OXFORDSHIRE COUNTY COUNCIL'S RESPONSE TO CONSULTATION ON THE FOLLOWING DEVELOPMENT PROPOSAL

Application no: 22/01144/F

Proposal: Full planning application for the erection of a new high quality combined research, development and production facility comprising of Class B2 floorspace and ancillary office floorspace with associated infrastructure including: formation of signal-controlled vehicular access to the A41 and repositioning of existing bus stops; ancillary workshops; staff gym and canteen; security gate house; a building for use as an energy centre (details of the energy generation reserved for future approval); loading bays; service yard; waste management area; external plant; vehicle parking; landscaping including permanent landscaped mounds; sustainable drainage details; together with the demolition of existing agricultural buildings within the red line boundary; and the realignment of an existing watercourse

Transport Schedule

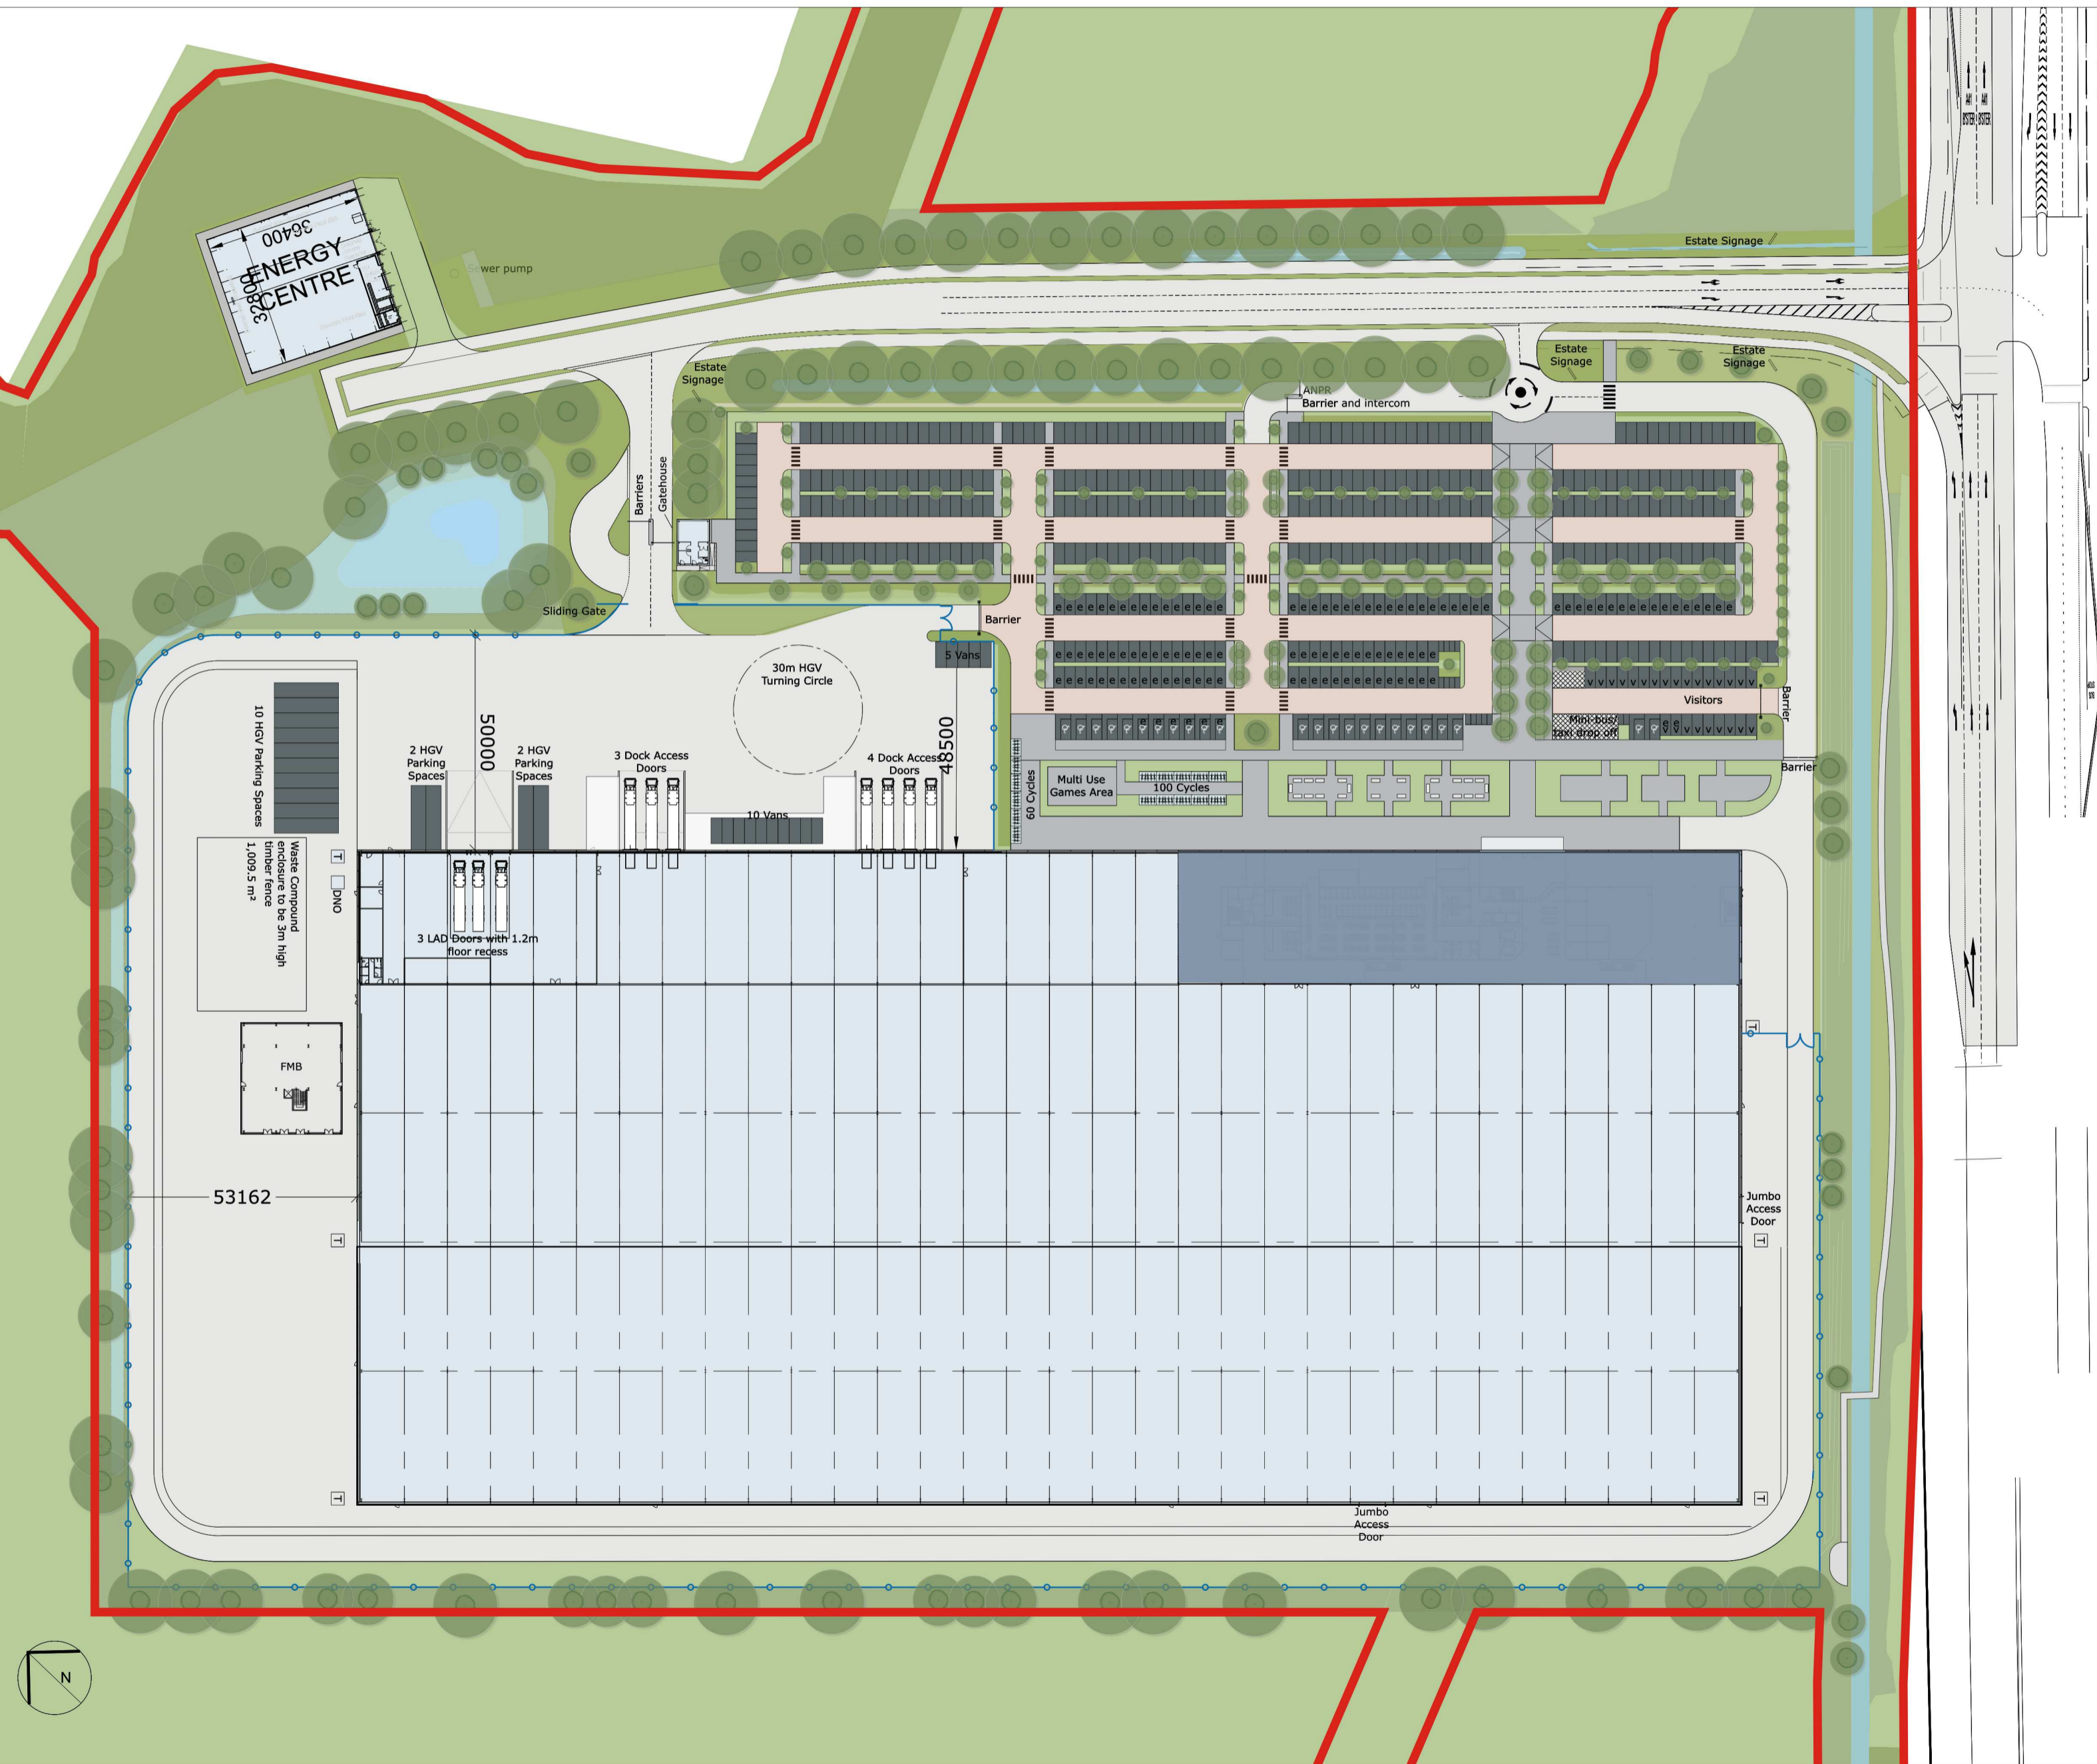
The level of car parking proposed has been based on expected demand, taking account of peak changeover times where workers will be arriving for the start of their shift while others are leaving at the end of theirs. The peak car parking demand, based on staff working at the site and changeover times is predicted to be 462 vehicles, while 474 car parking spaces are proposed to allow a degree of flexibility.

The level of cycle parking spaces provided on site is below that recommended for a development of this scale. However, taking account of the analysis of the number of staff on site and their likely destinations (at least in the shorter to medium term), the level of cycle parking proposed is likely to be sufficient. I note that the use of the cycle parking facilities will be monitored through the Travel Plan and that additional cycle parking spaces would be provided if and when required.

The location of the cycle parking facilities is appropriate. Long-stay / staff cycle parking facilities must be covered, and shower and locker facilities are to be provided on-site.

The internal layout appears to be appropriate. Footways are provided throughout the car park with informal zebra-style crossings provided where necessary. The car park is laid out appropriately, with disabled and EV charging parking bays provided towards the main entrance to the building.

The swept path analysis demonstrates that all vehicles likely to require access to the site would be able to safely and conveniently enter, turn and exit the site in a forward gear.
